Permit Number 4003194 2006

This is to certify that ADAMS DAVID & PAMELA JTS  
has permission to Demolish existing garage/ replace w/ 40 sq ft garage  
AT 79 PLYMOUTH ST L 343 B003001

<b>Proposed Use:</b> Single Family Home/ Demolish existing garage/ replace w/ 400 sq ft garage	<b>Proposed Project Description:</b> Demolish existing garage/ replace w/ 400 sq ft garage
---	---

FRAMING PLAN
e 1/2" SCALE

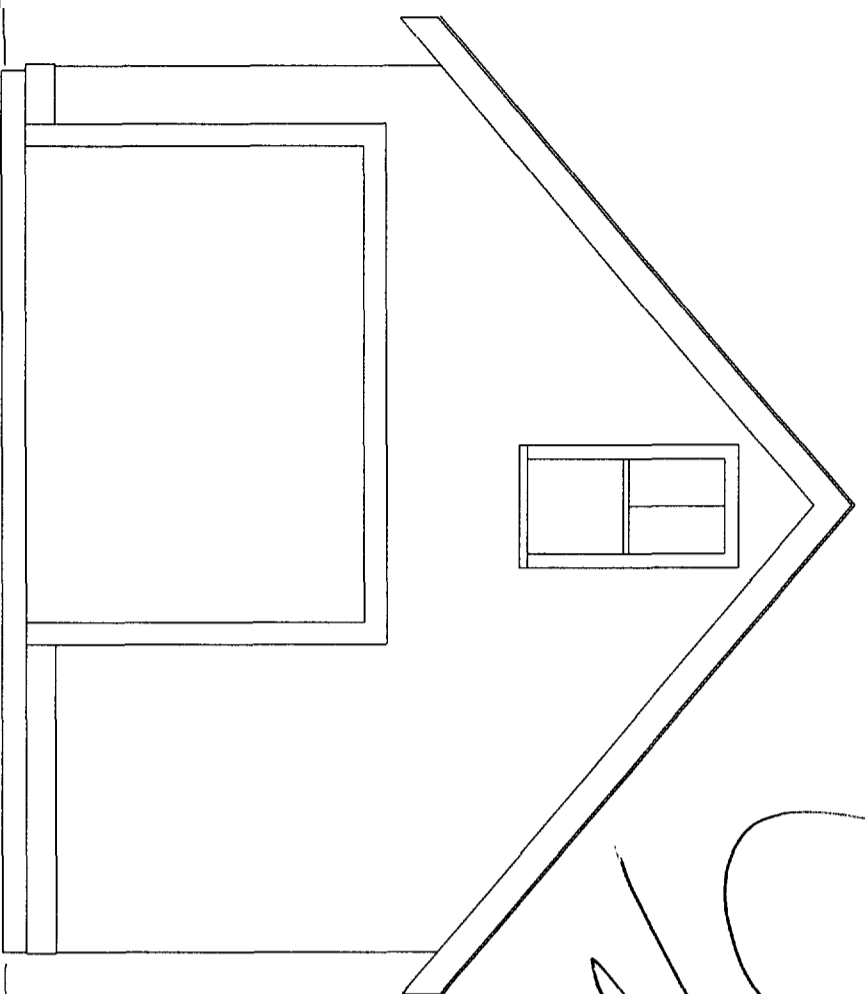
4/6/2006-jmb: Spoke w/David A. On roof framing details, he agreed to do either option on the rafters as noted on plans and all additional notes. Scheduled a demolition insp. For 4/10 before issuing the permit. Need to verify code requirement on slab detail.

4/11/2006-jmb: Left a vm to David A. To discuss the slab details

4/10/2006-jmb: David A. Left a vm to say the collar tie will be located in the lower 1/6 of the roof height.
